Application Reference Number:		2026/0292.	
Application Type:		Full.	
Proposal Description:		External alterations and installation of doorway to provide level access, as well as internal alterations including installation of platform lift and extension of ATM room.	
Location:		26 Market Hill, Barnsley, S70 2QE.	
Applicant:		NatWest Group.	
Third-party representations:	None.	Parish:	
		Ward:	Central.

Summary:			
The applicant is seeking planning permission for external alterations and the installation of a doorway to provide level access off Market Hill, and internal alterations, including the installation of a platform lift and the extension of an ATM room. Extensions and alterations to existing buildings are acceptable in principle if the development would remain subservient and be of a scale and design which would be appropriate to the host property and would not be detrimental to the amenity afforded to adjacent properties, including visual amenity and highway safety. Development should also set out to conserve and enhance the significance and setting of the borough's heritage assets. The proposal is considered acceptable regarding its potential impact on design, heritage and vi

Project: **Level Access Program**
 Title: **Barnsley Proposed Plan & Elevation**
 Client: **NatWest Group**
 Purpose: **For planning**
 Drawing Number: **7119-JMA-14-00-DR-A-000012**

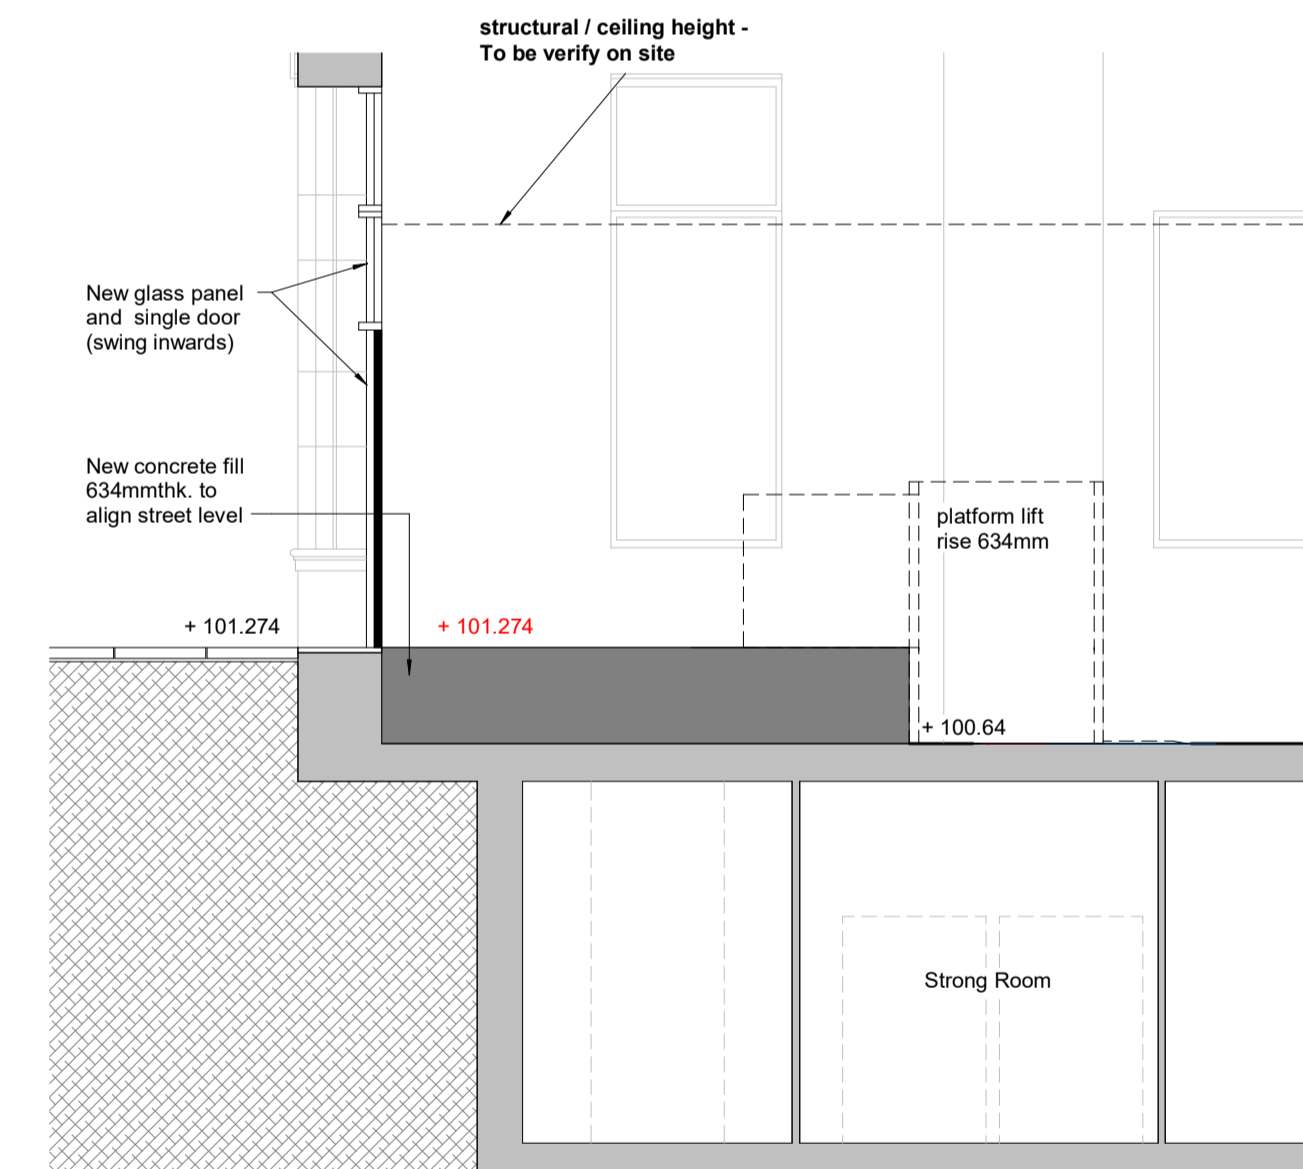
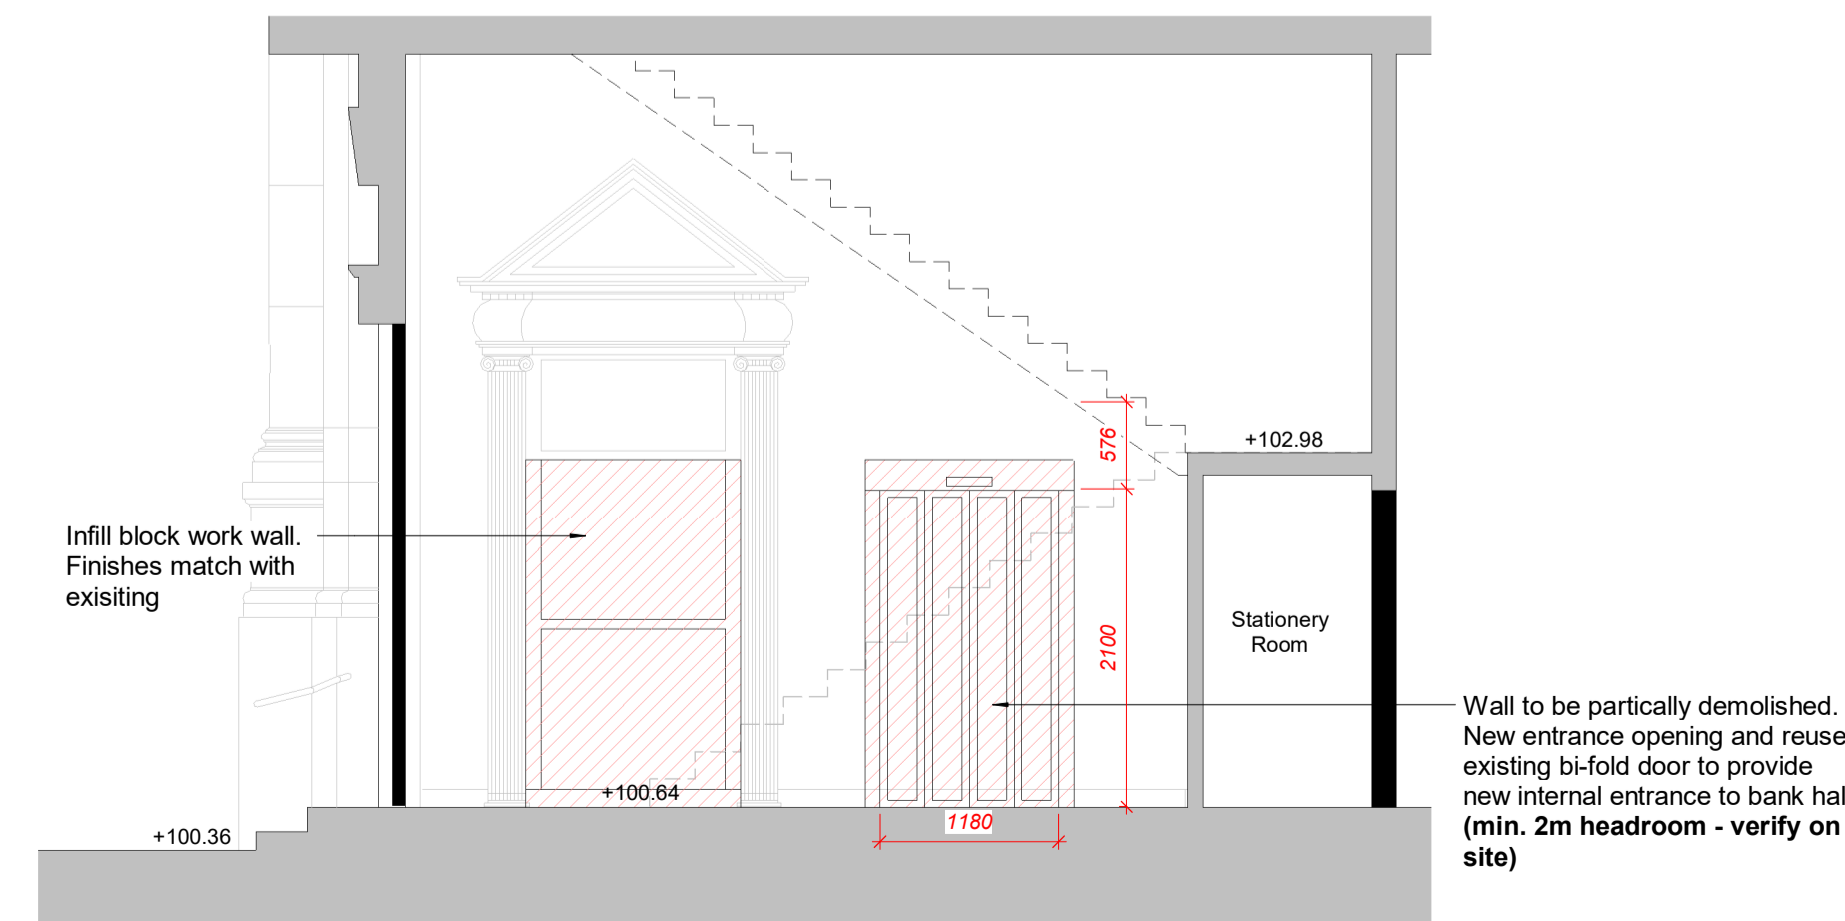
The primary consideration from a conservation perspective is the proposed alteration to the external fabric of the application building through the replacement of the existing ground floor window located at the northernmost end of the west elevation with a new doorway, which would result in the loss of a section of low-level stonework.

Notwithstanding the above and the submitted details, additional details should be provided in respect of the design and detailing of the proposed doorway that ensures that it would sit comfortably within the existing opening in respect of proportions, materials and colour. These details could be secured by the imposition of a suitably worded condition.

4. Notwithstanding the submitted details, prior to the installation of the doorway hereby approved, full detailed drawings of the new door and frame (at a scale of 1:10 or 1:20), including cross-sections and reveals, and samples or a specification of the materials and external finish shall be submitted to and approved in writing by the Local Planning Authority. The development shall be carried out in accordance with the approved details and retained thereafter.

5. The external materials shall match those used in the existing building and specified by the approved documents listed above. The stone shall match the existing in terms of type, colour, and face dressing (for the stone) and method of coursing and pointing. The quoining and arch jamb shall also match the existing.
